**Our ref:** NO/2025/116806/01-L01  
**Your ref:** 3/2025/0377  
**Date:** 27 May 2025

**PRIOR APPROVAL FOR THE PROPOSED CHANGE OF USE OF A FORMER AGRICULTURAL BUILDING TO ONE DWELLINGHOUSE UNDER SCHEDULE 2, PART 3 CLASS Q OF THE GPDO.  
FIELDS FARM, MEARLEY, PENDLETON, BB7 1PU**

name **location plan**

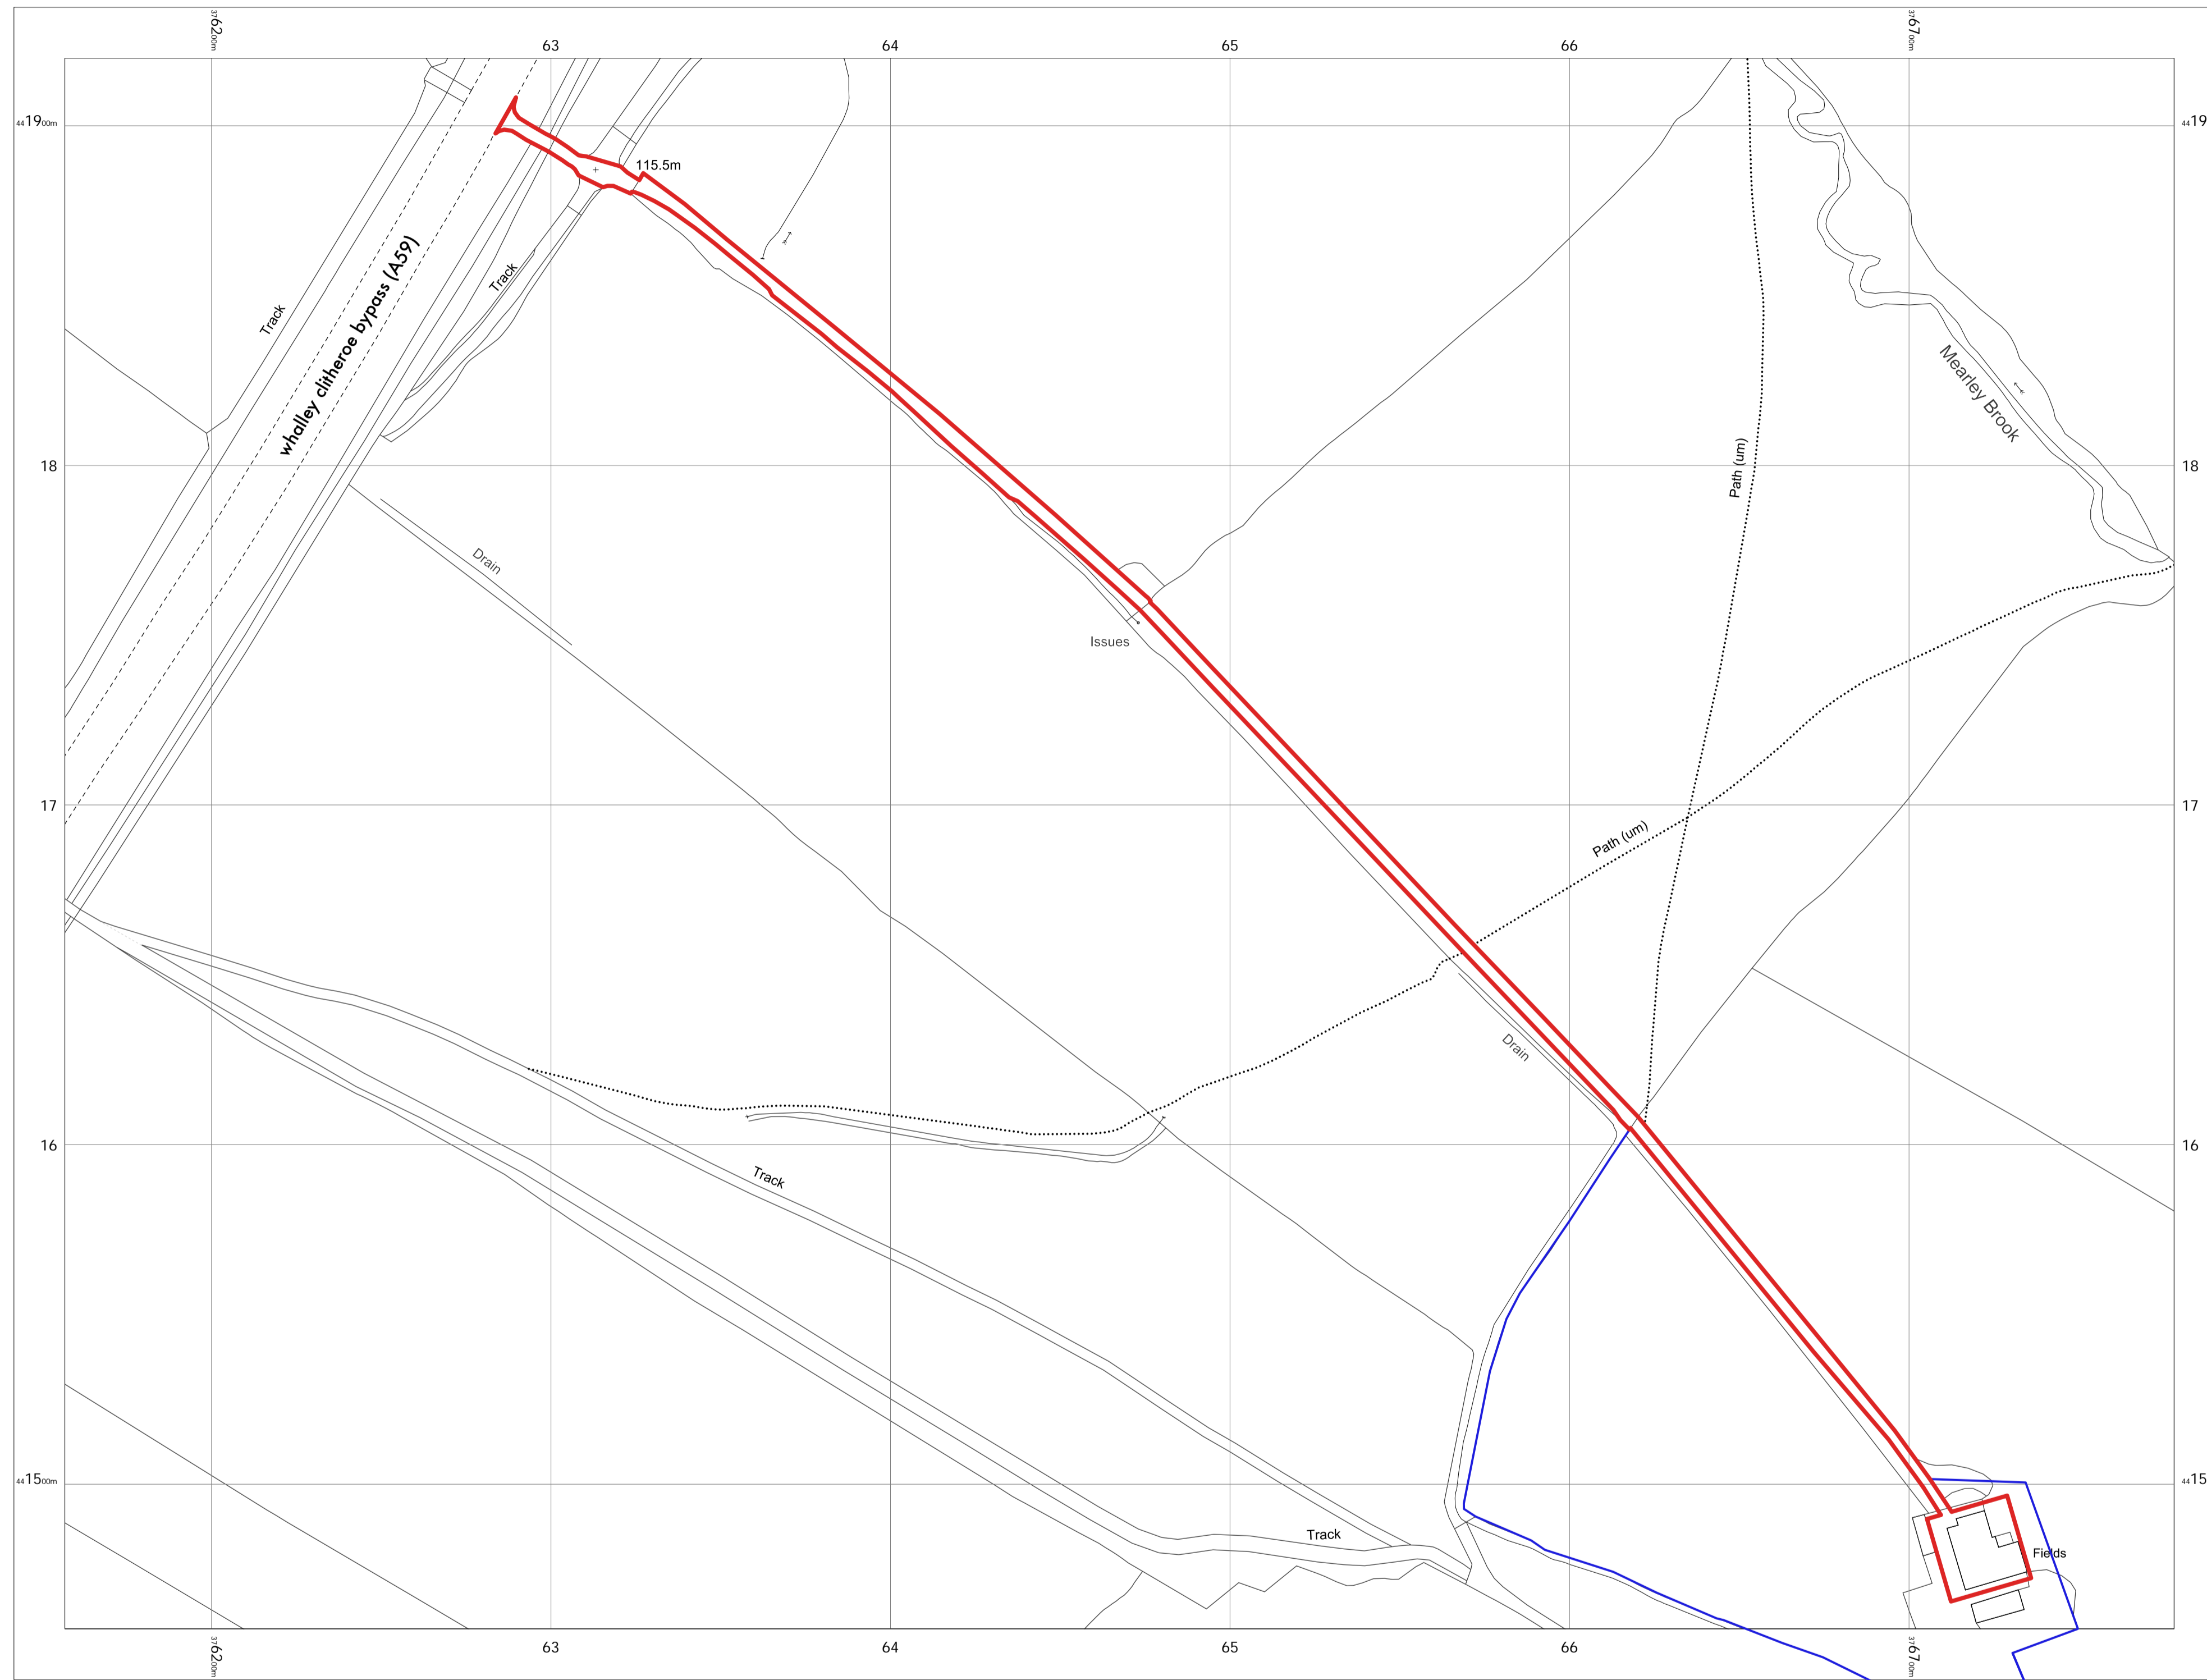
The red-edge boundary of the planning application includes an area that is located within Flood Zone 3, which is land defined by the planning practice guidance as having a high probability of flooding. The National Planning Policy Framework (paragraph 167, footnote 55) states that an acceptable FRA must be submitted when development is proposed in such locations.

While the application boundary, specifically part of the access road, falls within Flood Zone 3, the proposed development is wholly within Flood Zone 1, which is land defined as having a low probability of flooding. As no development is proposed within Flood Zone 3, there are no tidal or fluvial flood risks that we would expect to be considered through a more detailed FRA.
